UTE PASS STORAGE
FINANCIAL ASSURANCE ESTIMATE MEMORANDUM
February 15, 2018

Subject: Engineer
Page Label: 1
Lock: Locked
Author: dsdgrimm
Date: 7/13/2018 9:06:22 AM
Color: ■

**SITE GRADING & EROSION CONTROL PLAN**

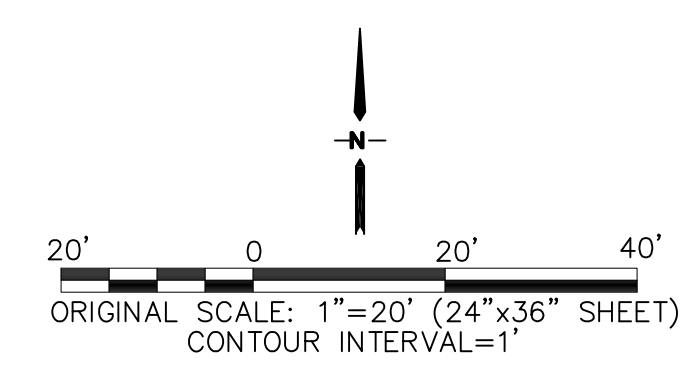
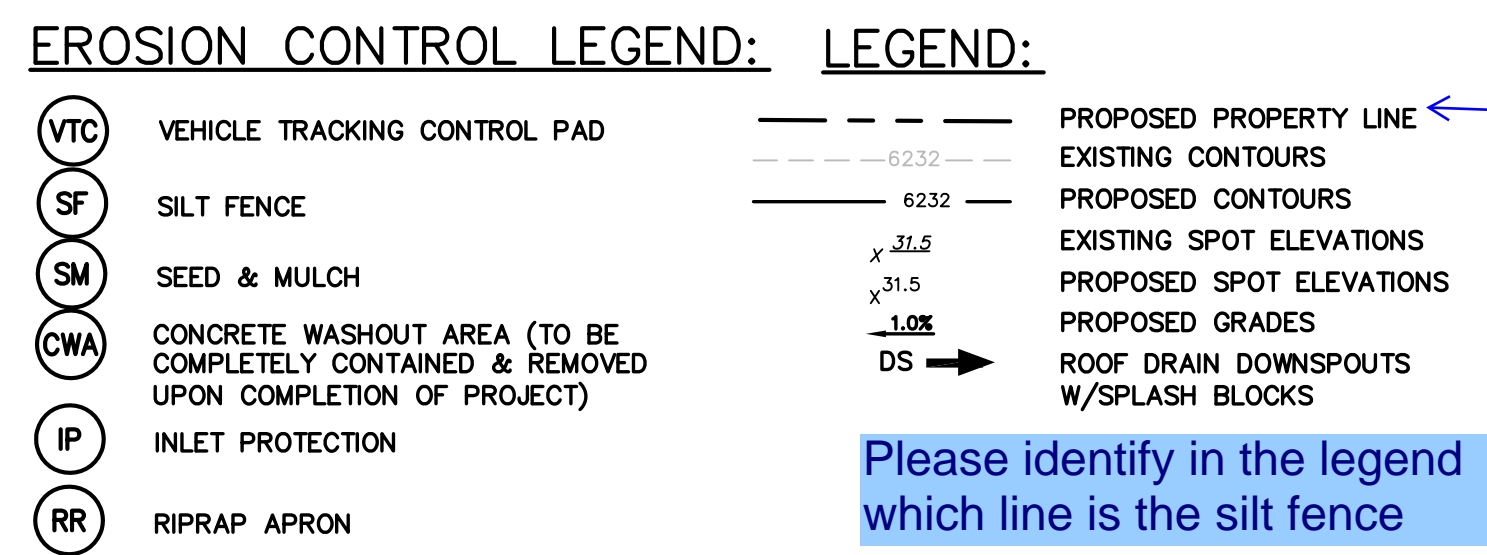
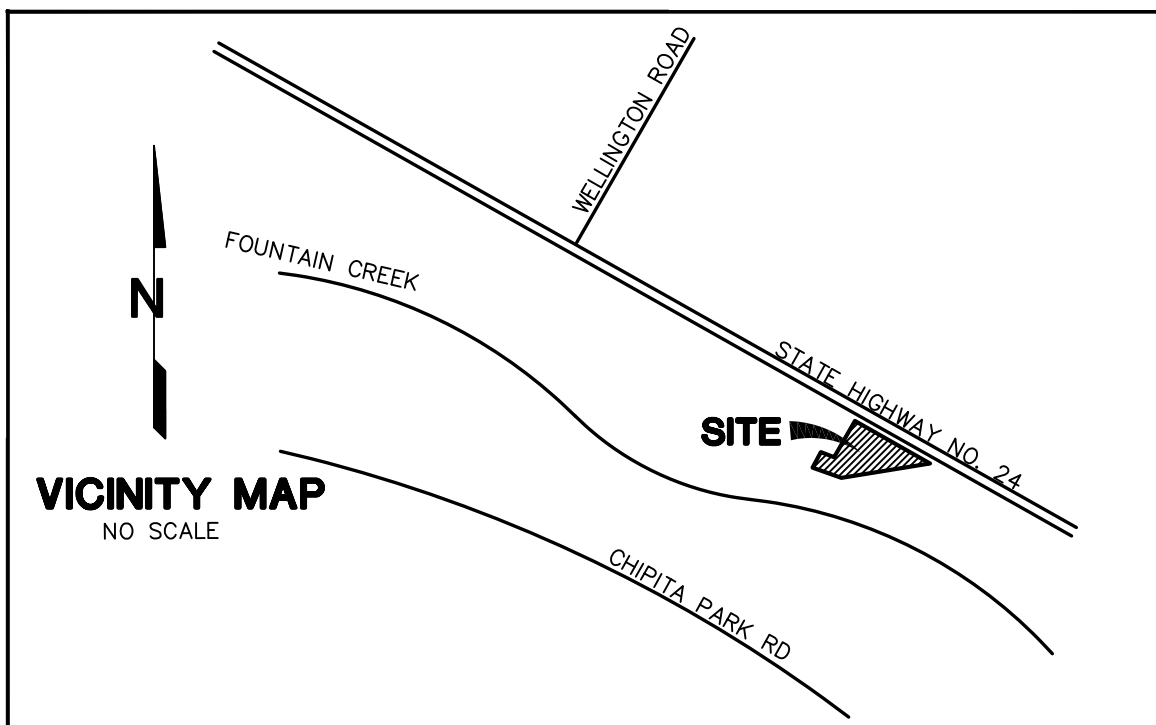
If an ESQCP is being submitted, then a financial assurance estimate is required for the grading and erosion control BMPs.
